Re: M/62/17/HH Proposals at 2 Elmer Court.

Drawing No. 1645/2010E

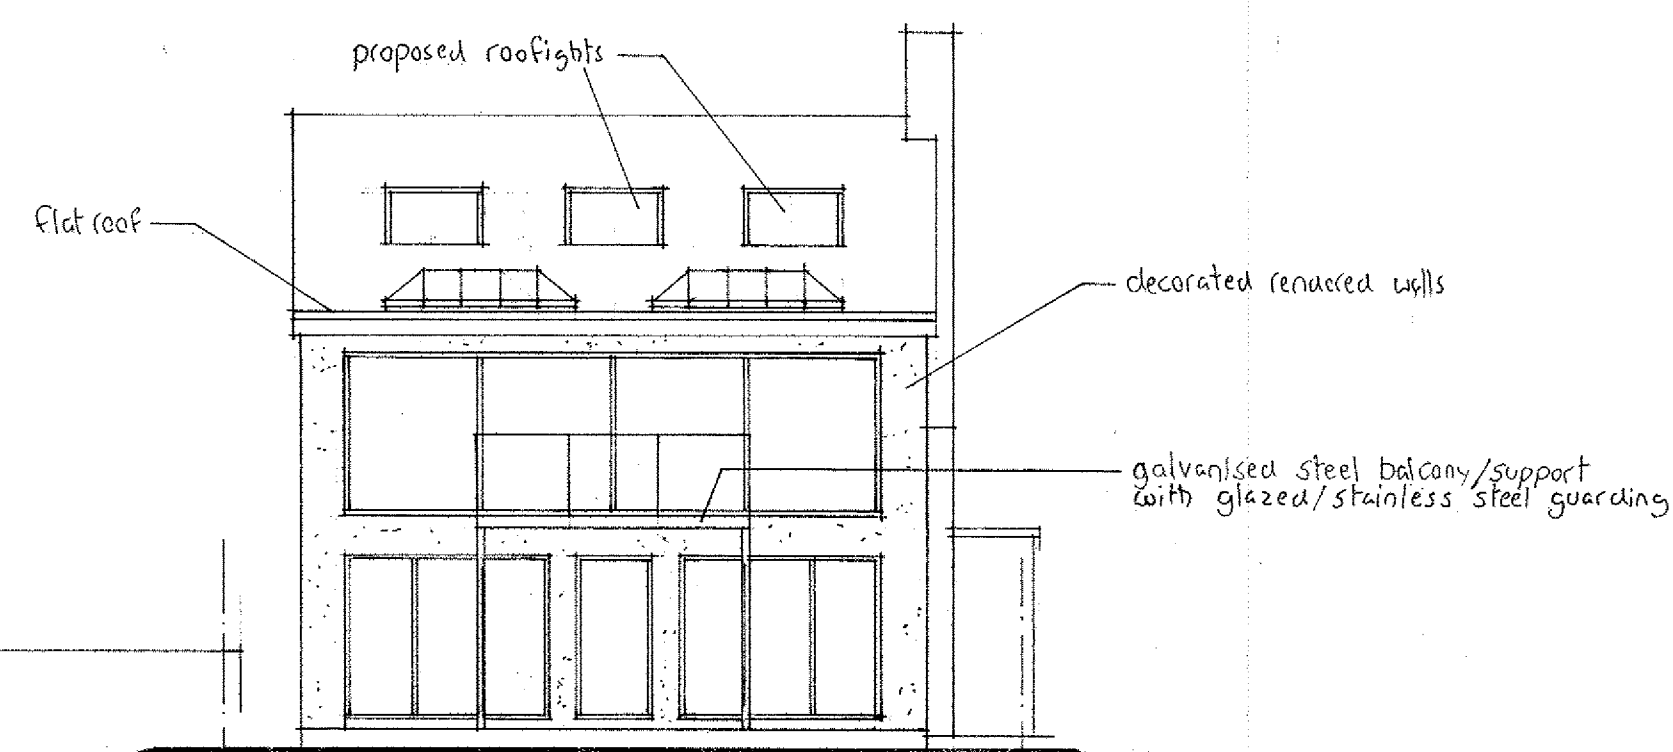
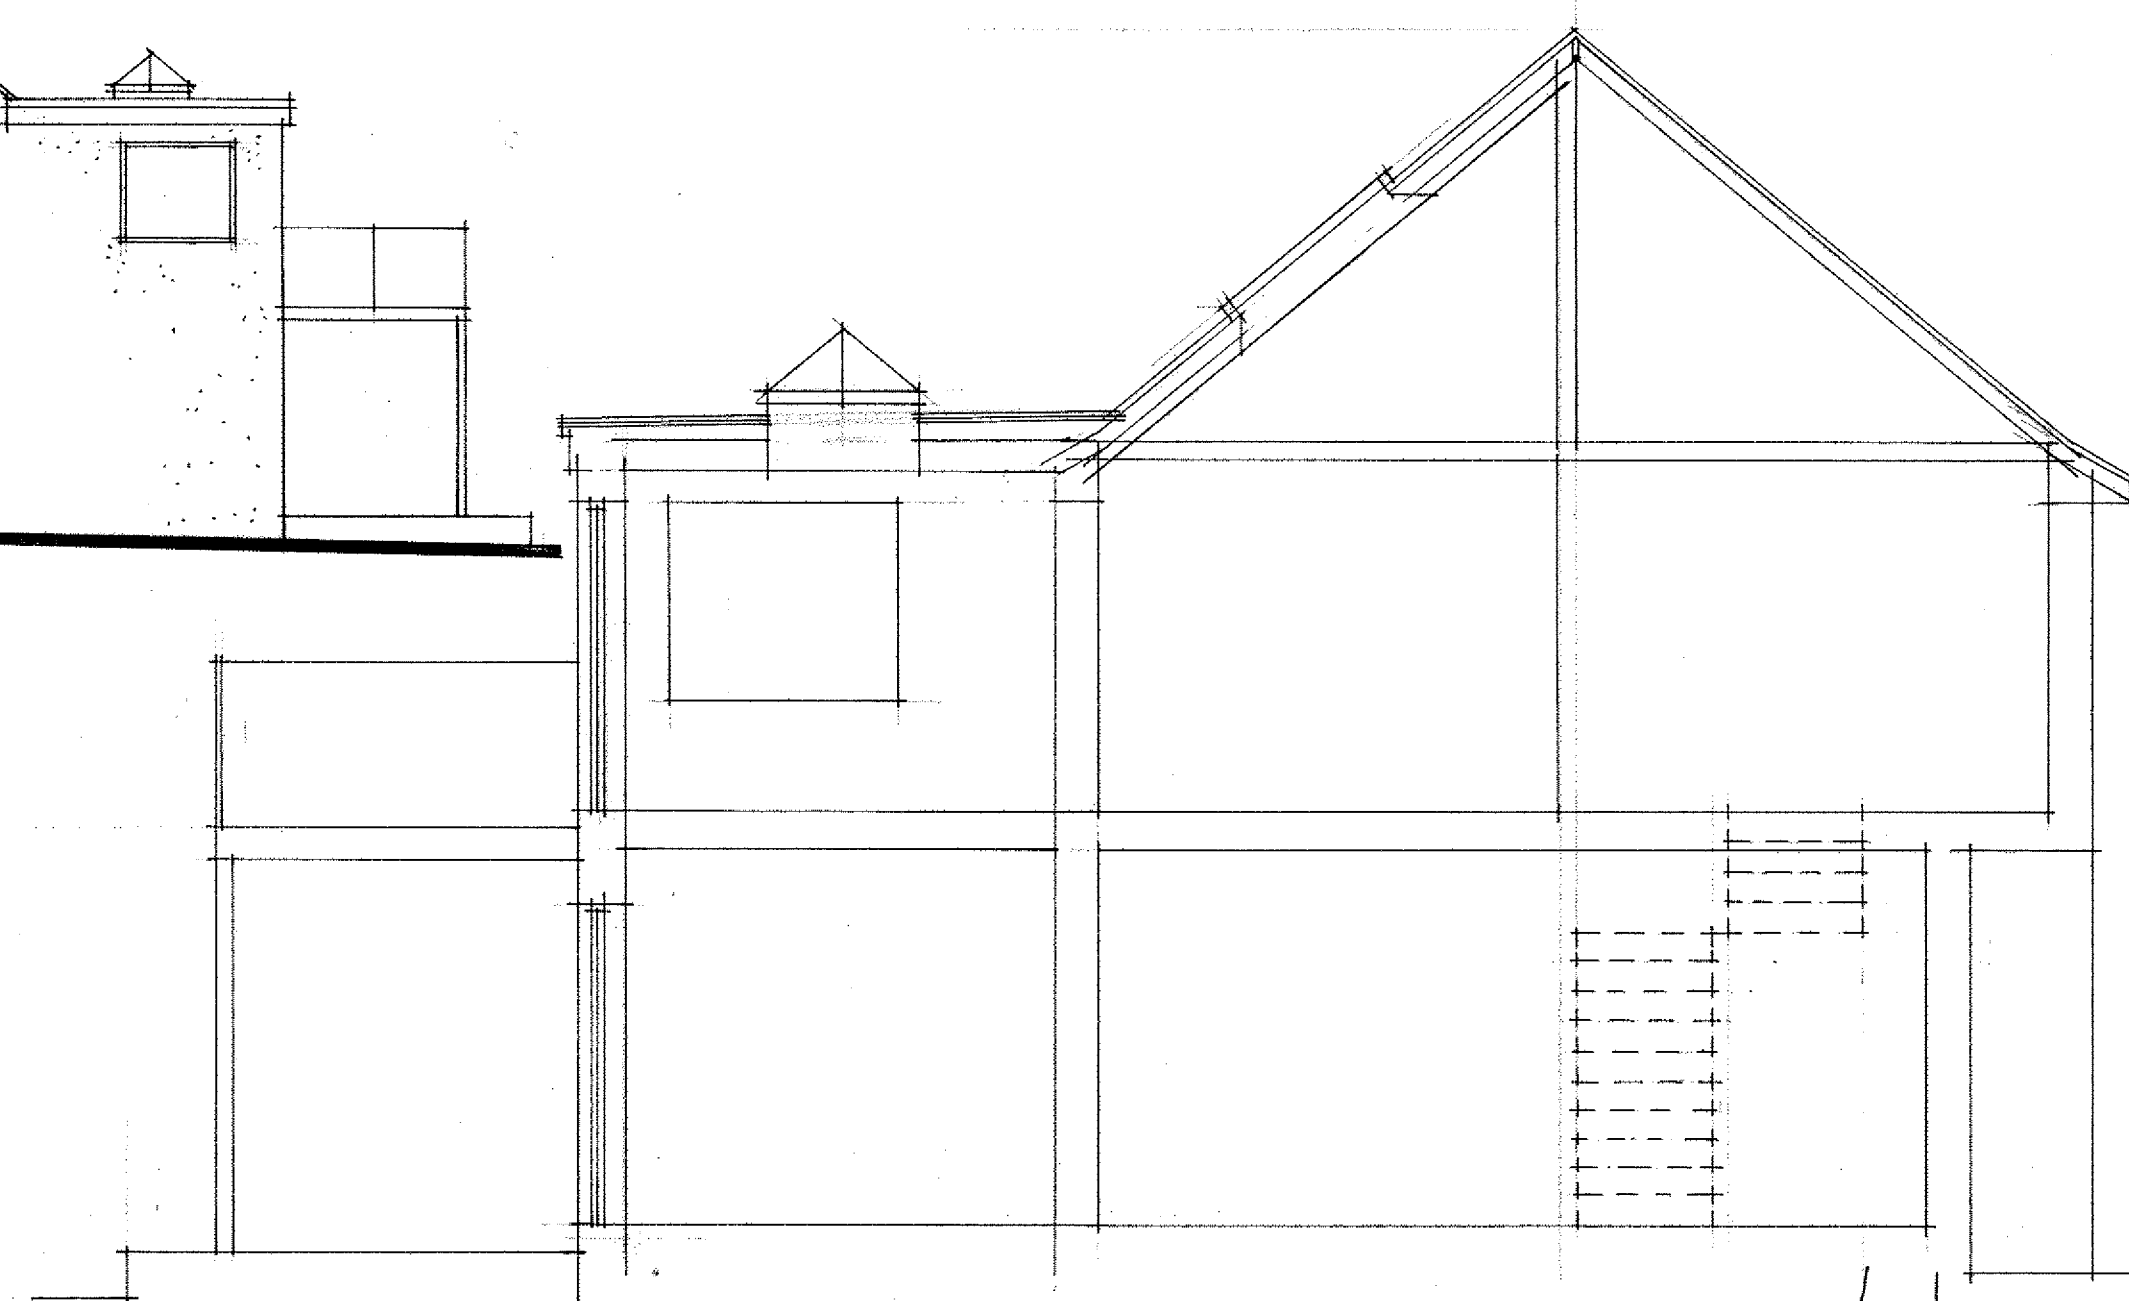
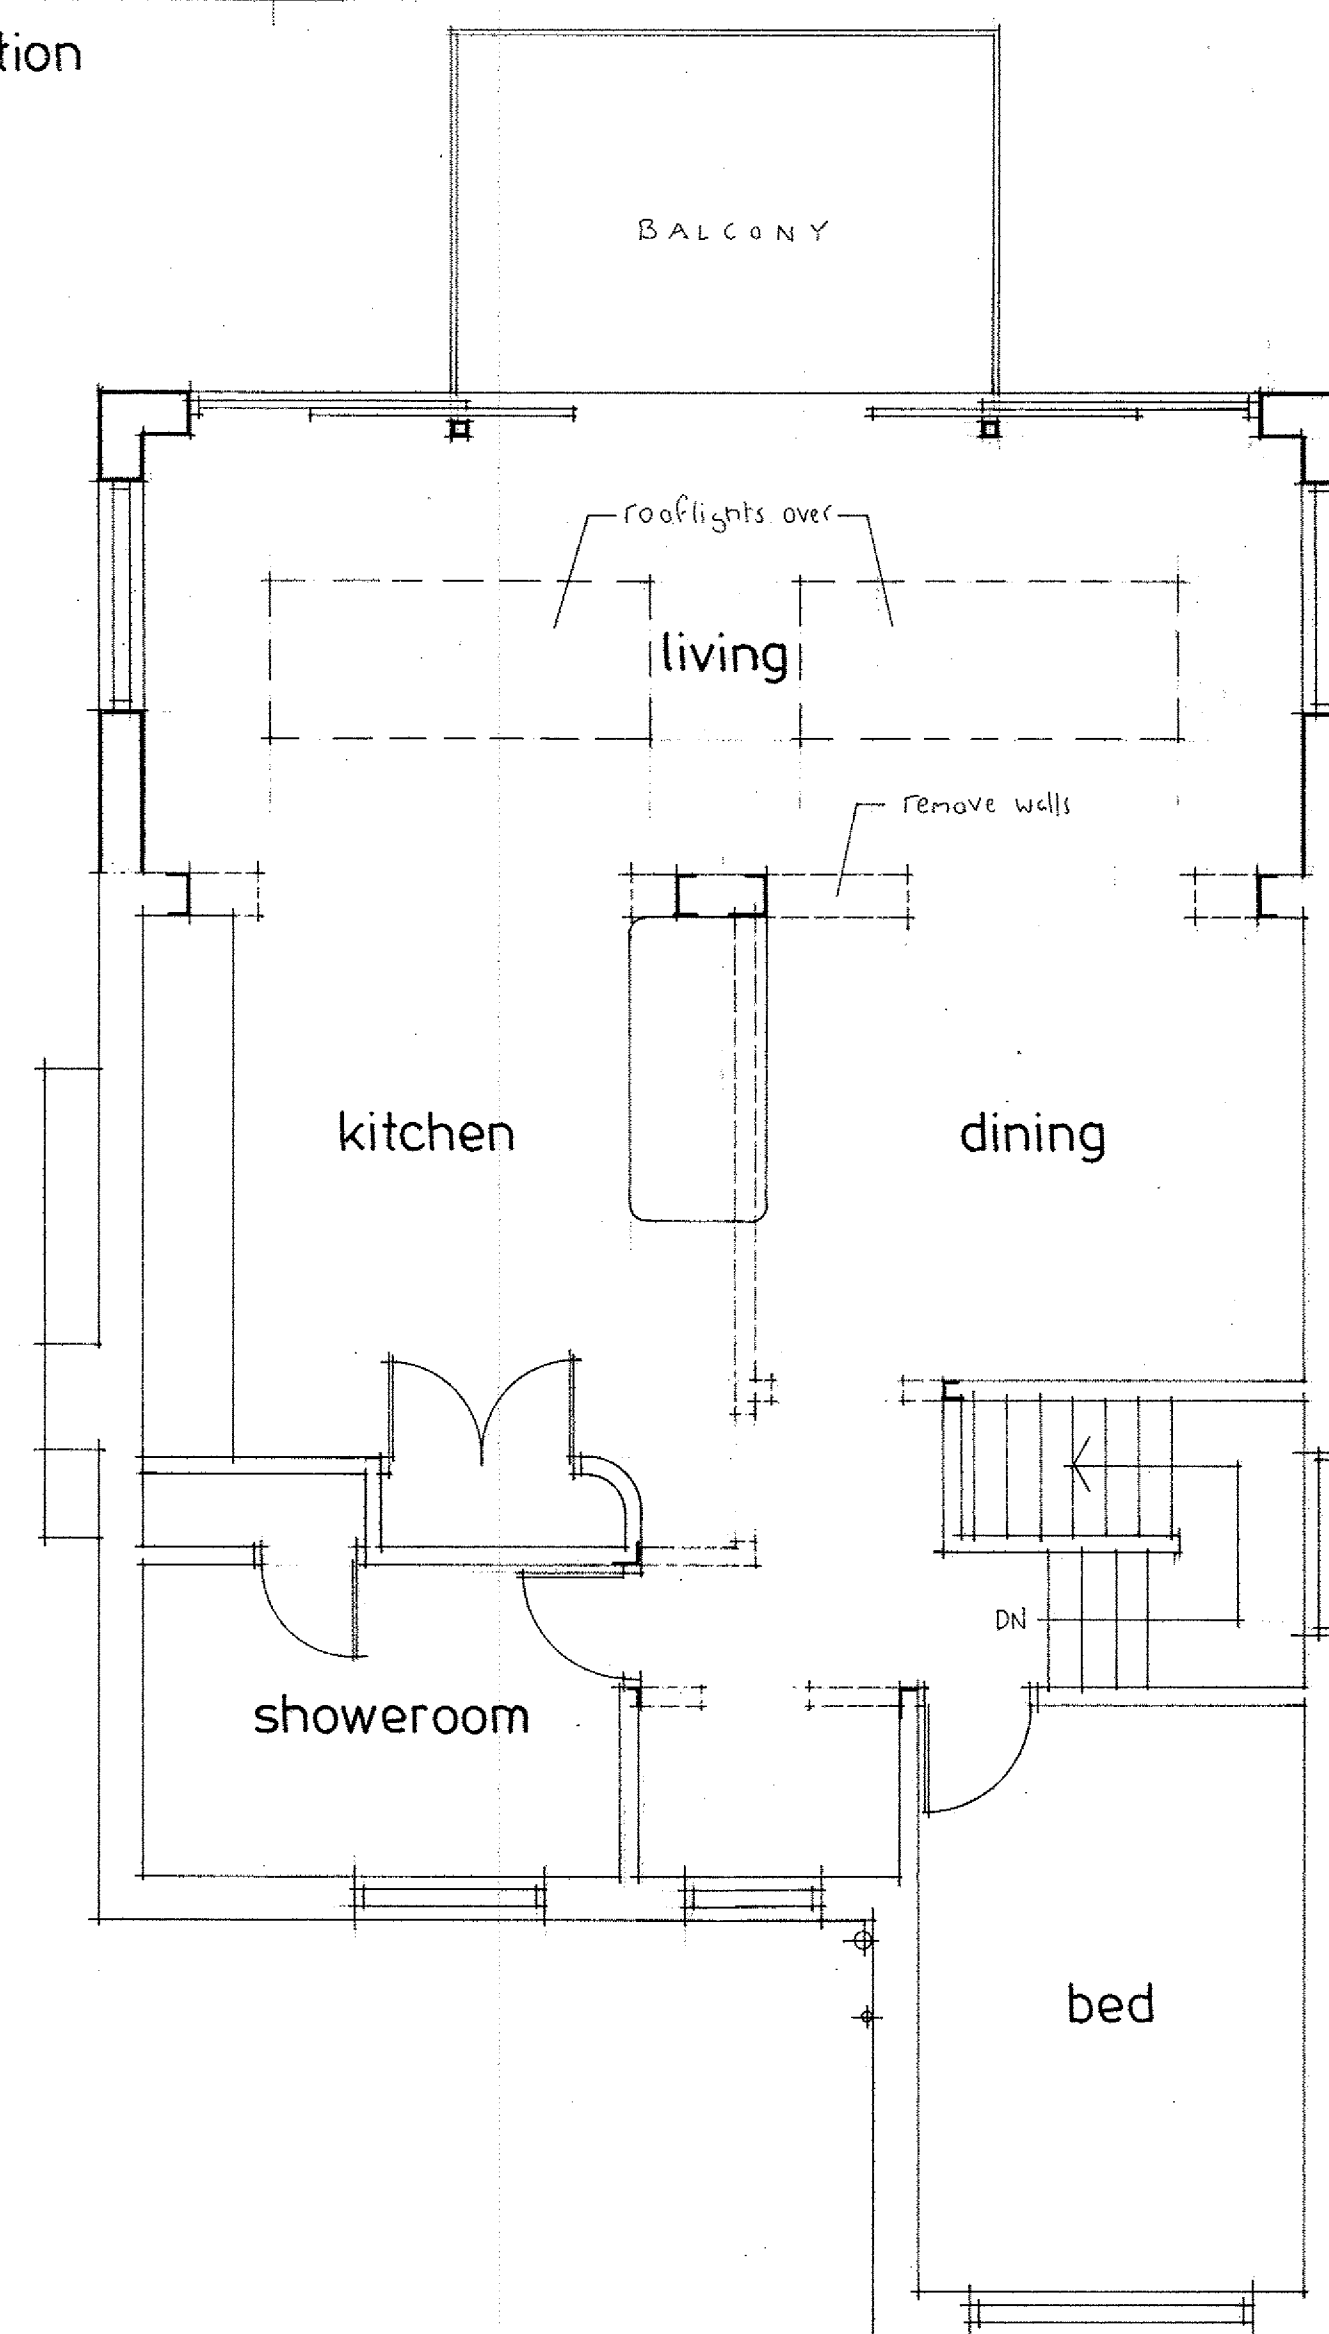
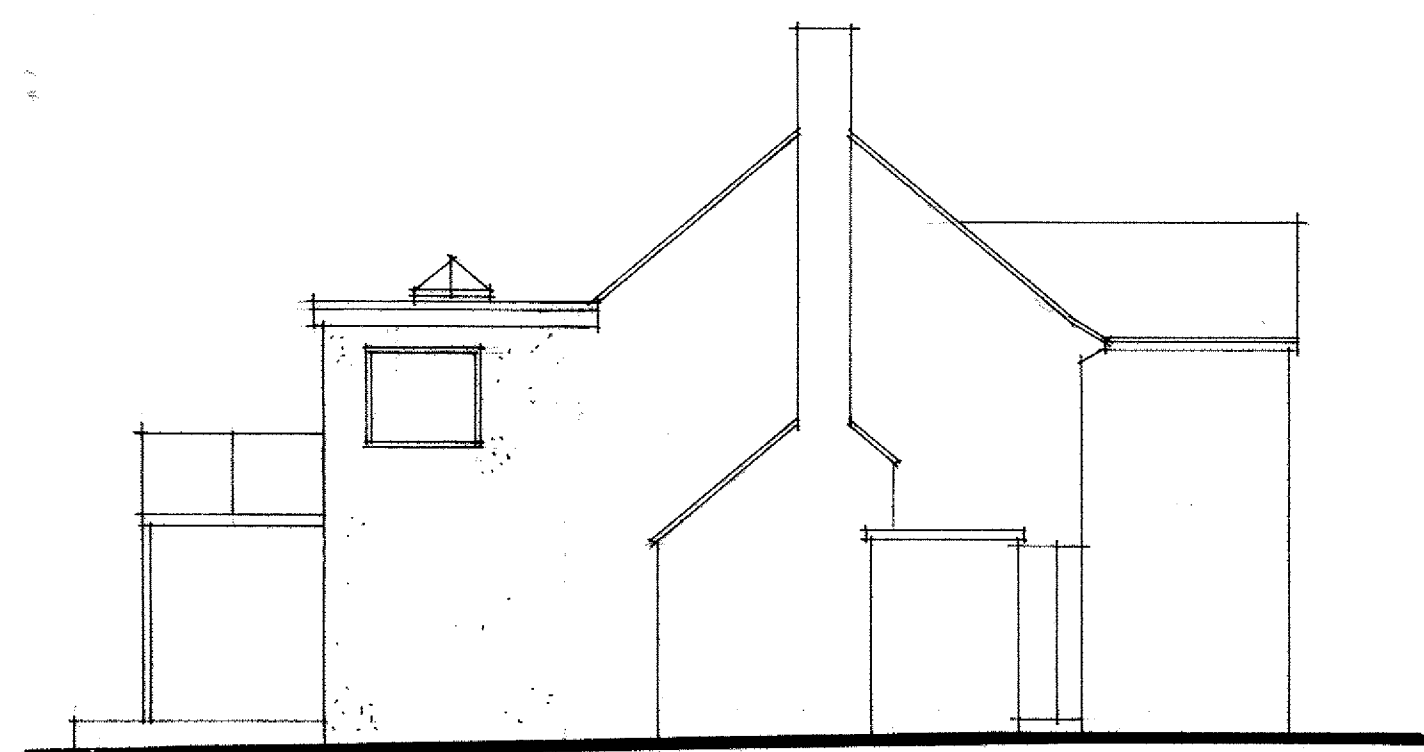
- Removal of the proposed external staircase.
- Inclusion of 1.8m high screening to the eastern and western boundaries of the proposed balcony.
- By virtue of the addition of the proposed screening it is likely that this will give rise to some additional overbearing impacts by virtue of the balconies depth – therefore, you may wish to consider reducing the depth of the balcony to mitigate against this.

1. Proposed external stair removed.
2. Balcony width reduced.
3. Glazed/stainless steel guarding shown.

We have chosen to considerably reduce the overall width of the proposed balcony from 7.3m down to 3.6m. As a result the sides of the balcony will be a good distance away from the side boundaries and neighbouring properties.

Due to this reduction in size we have chosen not to provide screening at the sides, however if you feel screening would be necessary, then we accept this (possibly as a condition).
